DECISION DELEGATED TO HEAD OF PLANNING

Application No: H04-0507-23 **Applicant:** Mr P & S Hilton

Proposal: Details of external gas & electricity boxes, landscaping, tree planting, site levels, floor levels, hard surfaced areas, garden/amenity areas, soakaway system and ecological biodiversity measures. (Conditions 3, 5, 6, 7 and 9 of H04-0037-23)

Location: 11 Badgate Road Donington Spalding

StormCrate55

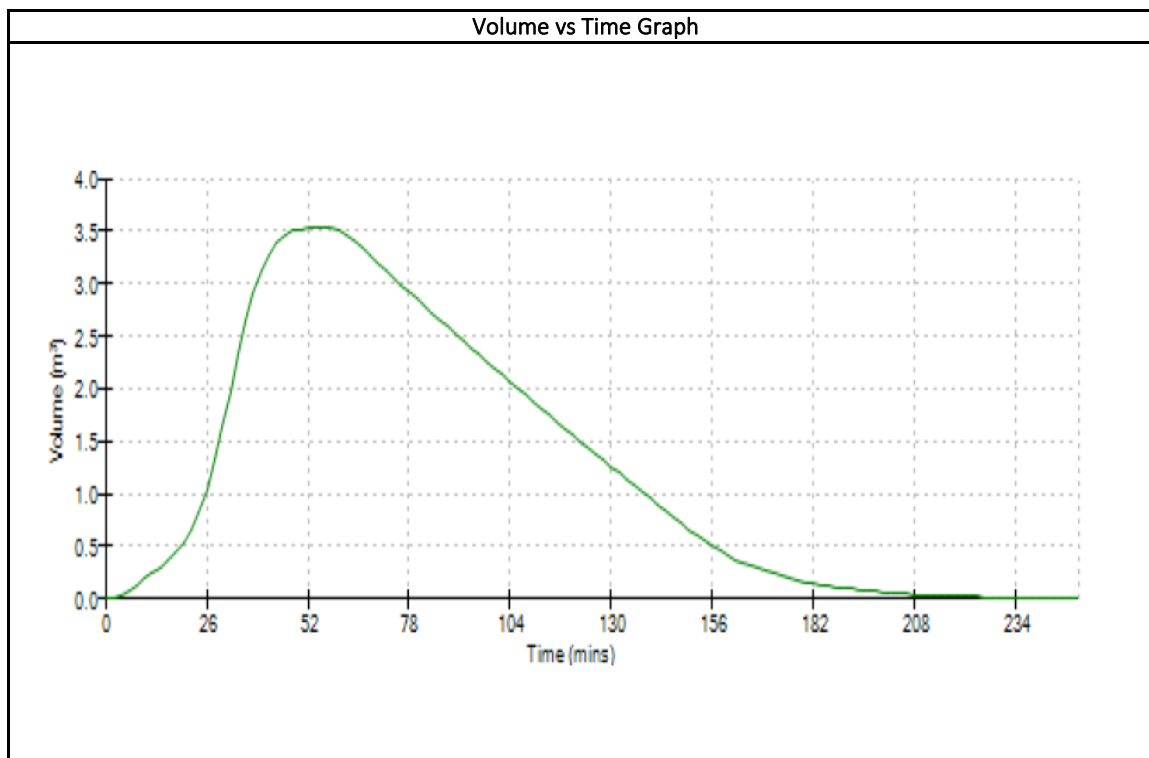
These discharge rates are considered to be acceptable with the soakaway being considered to be an appropriate means of addressing surface water drainage. Full details of the StormCrate 55 soakaway system have been supplied, which show that the soakaway provides an acceptable flow rate.

PROPOSED GARAGE

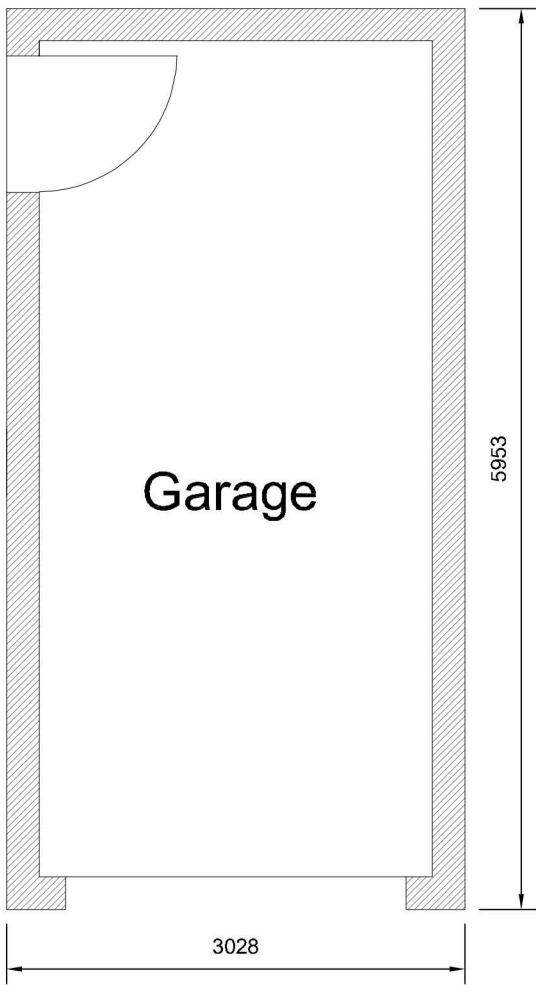
The submitted plans propose a swift brick to the west facing front elevation of the detached garage, with an additional brick to the east facing rear elevation.

Whilst additional measures would be appreciated, Condition 9 of H04-0037-23 has now been addressed.

PROPOSED ELEVATIONS

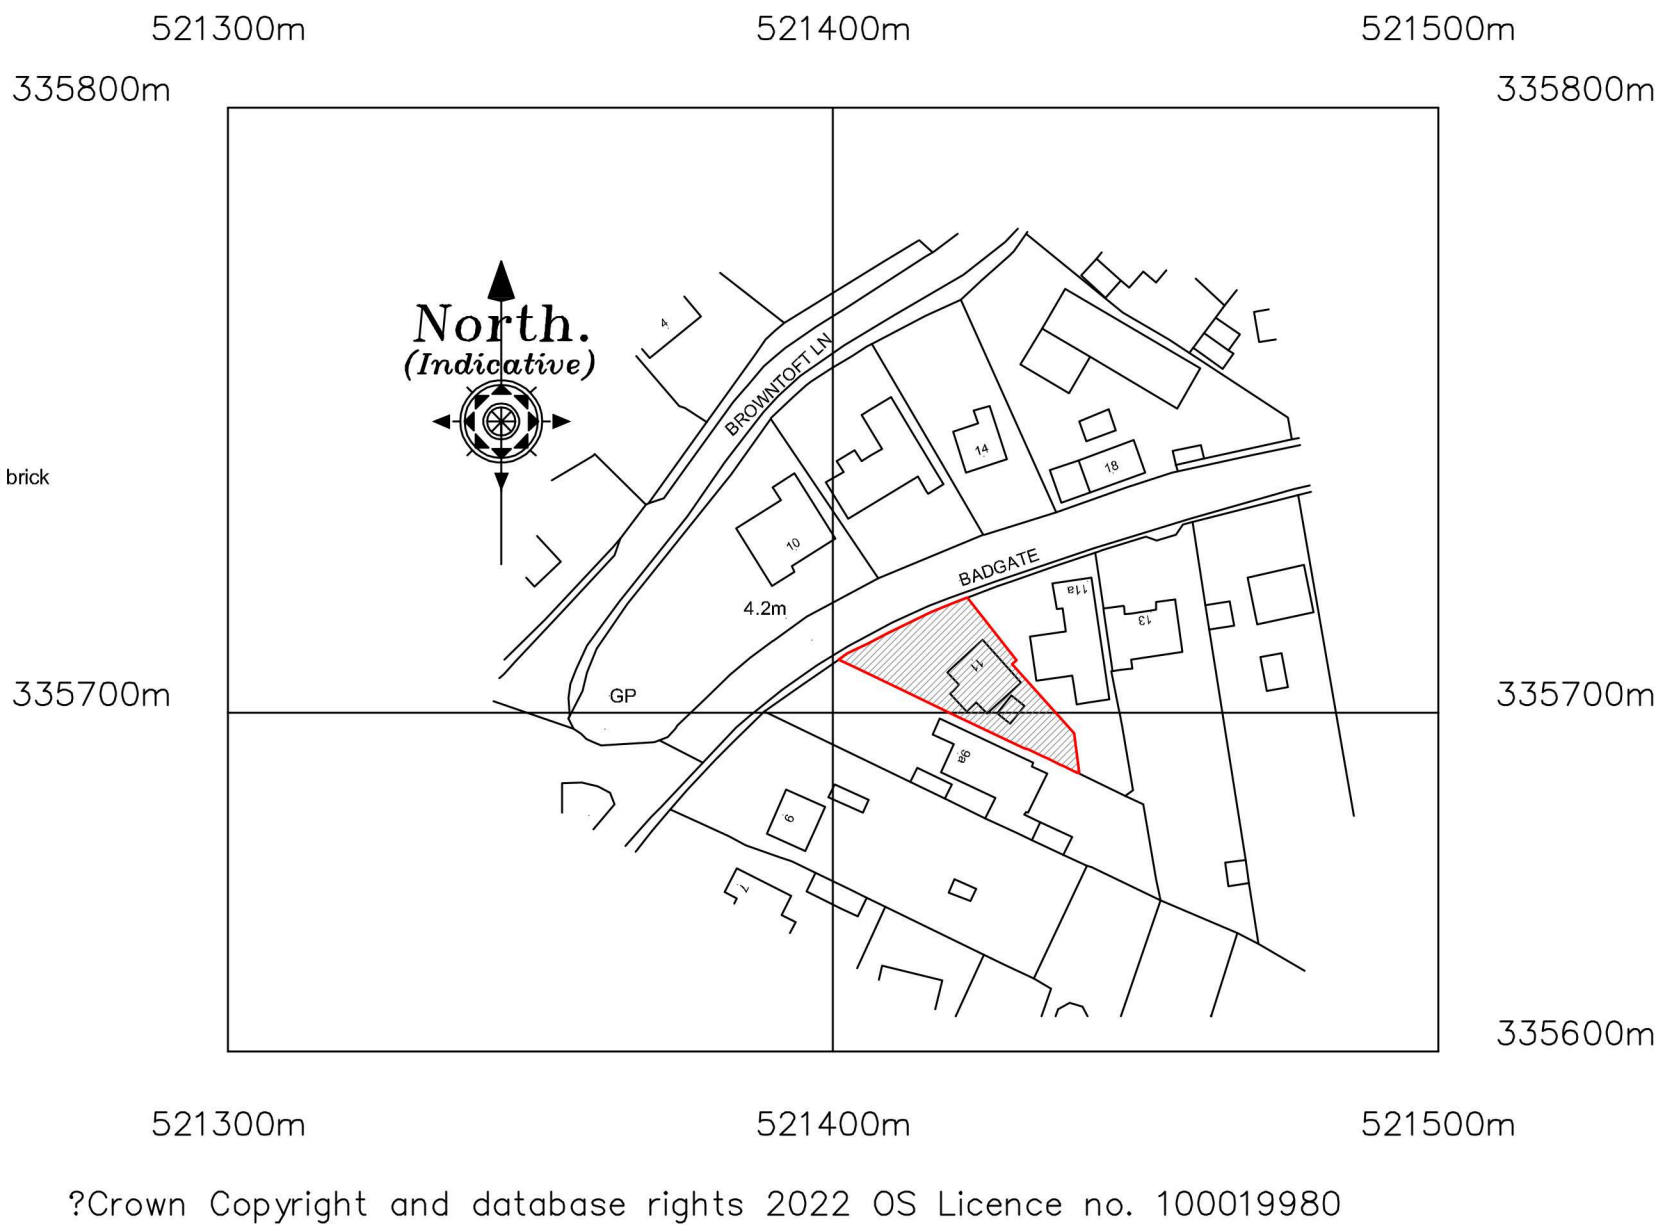
The proposed gas and electricity meter boxes are site below the utility window on the east facing side elevation of the bungalow. These boxes are not visually prominent, do not impact the character and amenity of the surrounding area, and is considered to be appropriately sited.

PROPOSED BLOCK PLAN

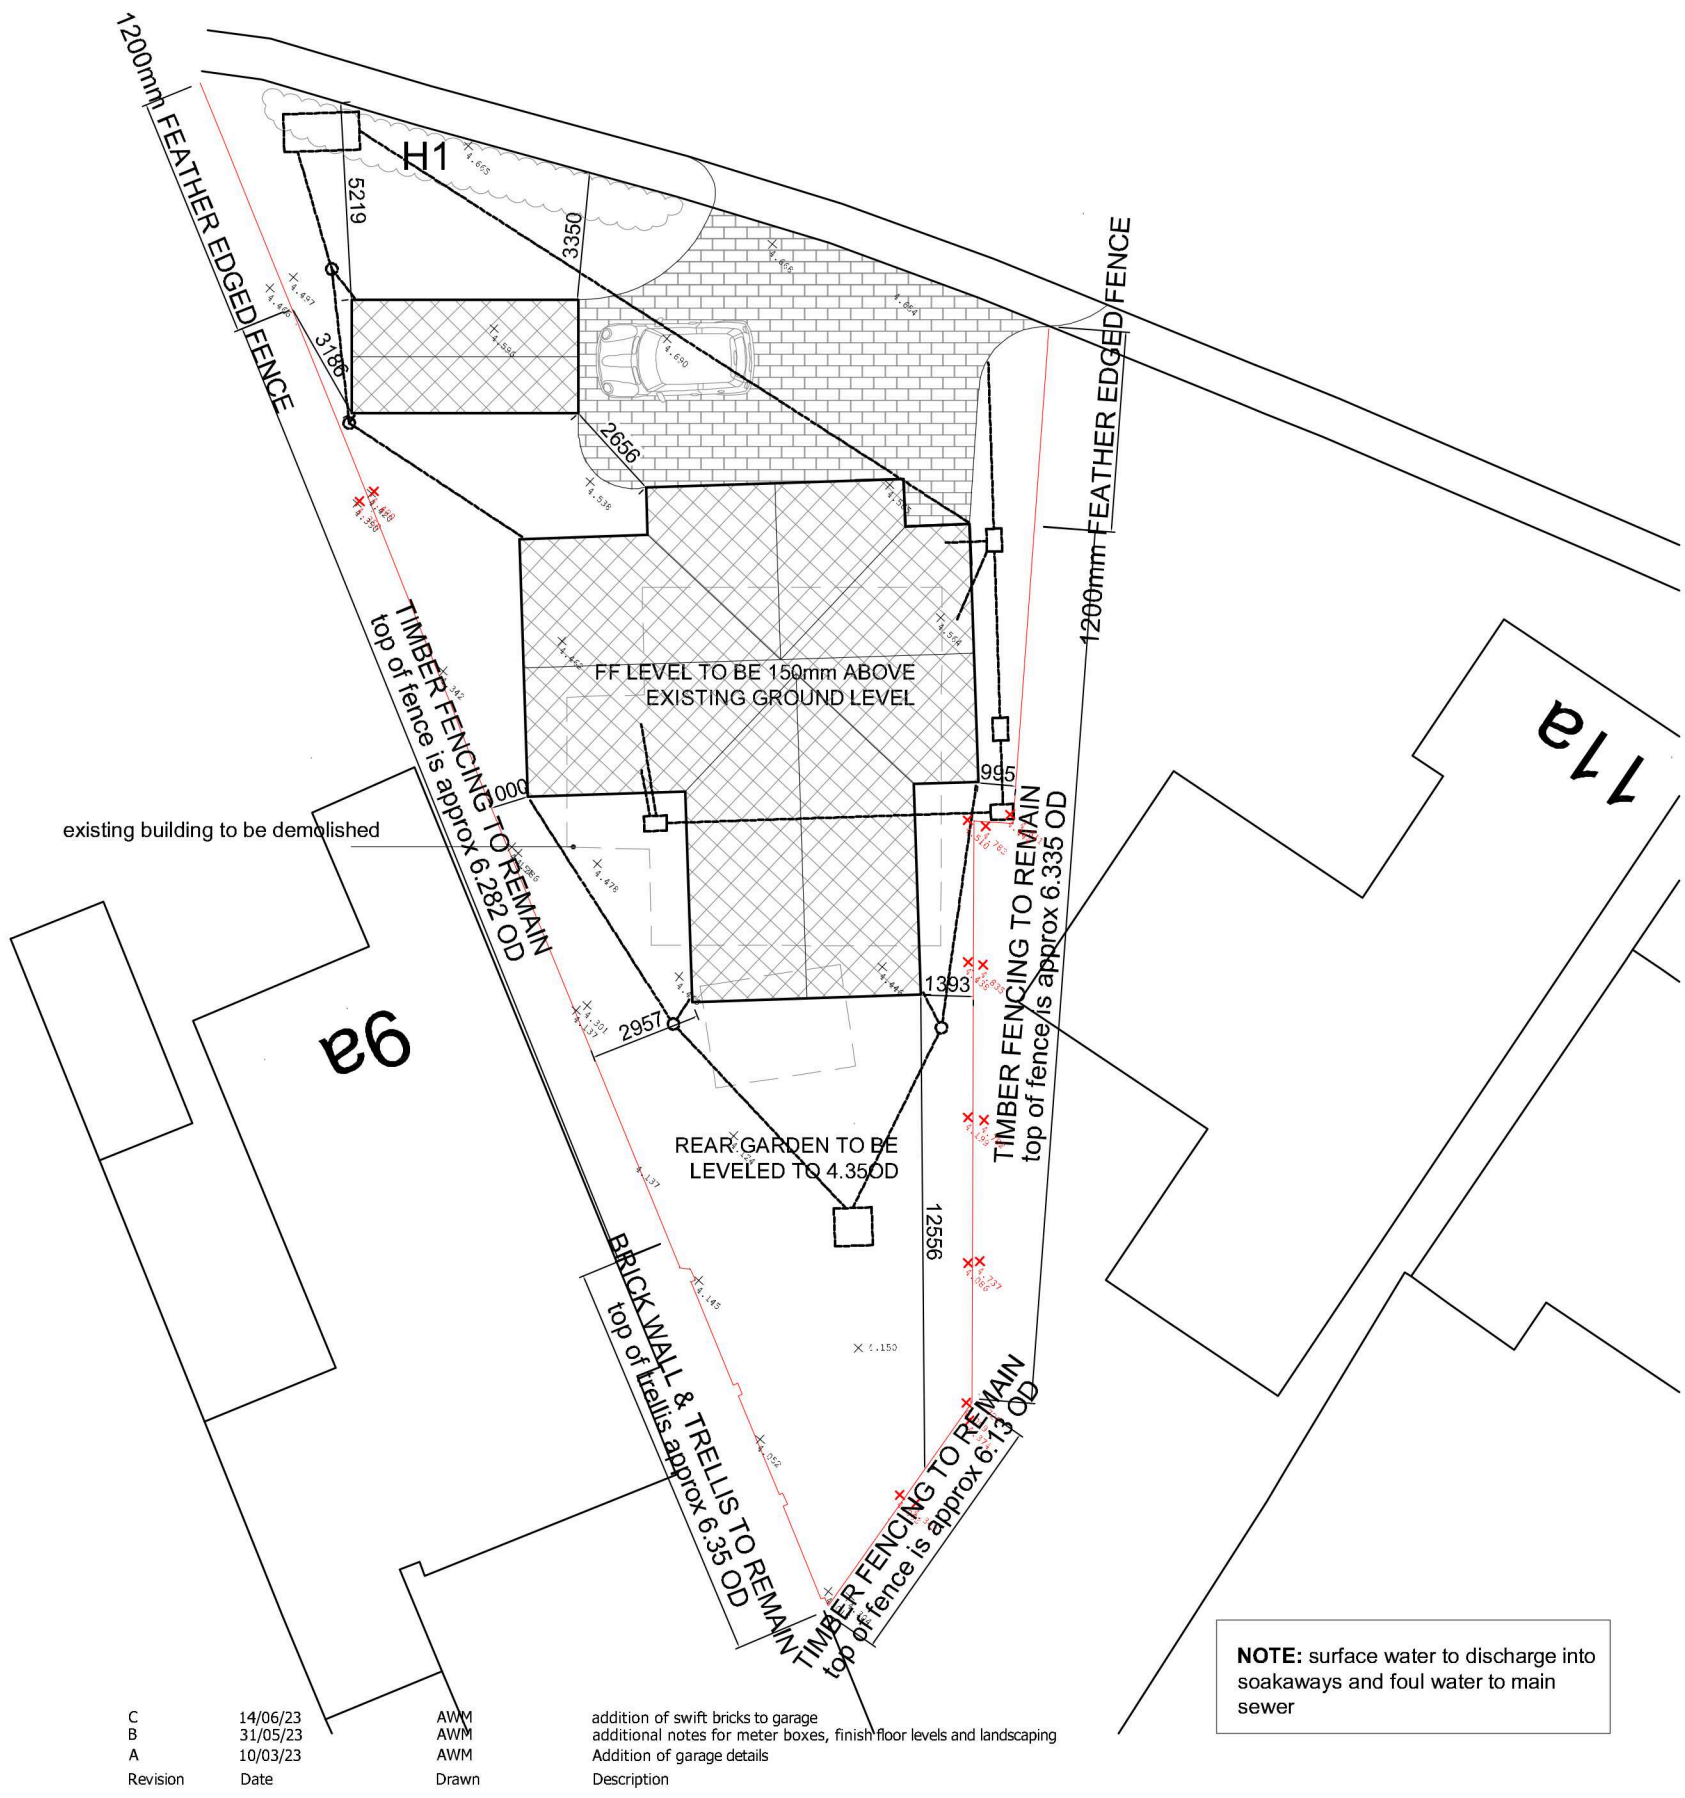
A frontage hedge is proposed adjacent to the detached garage, and will be maintained at a height of 1.2 metres. No further planting is proposed. Given the narrow nature of the garden area to the rear of the site, the proposed amount of planting is considered to be acceptable for the site.

The frontage of the site averages around 4.65mAOD, with the dwelling frontage around 4.55mAOD, the rear at 4.45mAOD, with the bottom of the garden at 4.05mAOD. The rear garden is to be levelled at 4.35mAOD. Given that the bungalow has a finished floor level of 150mm above ground level, and not subject to increased flood risk, the timber fencing to each side of the plot will be approximately 1.9 metres above the proposed levelled rear garden, so there is not considered to be

a material overlooking or overshadowing impact from the bungalow. The new bungalow is lower in height than the existing bungalow so amenity impact is considered to be reduced.
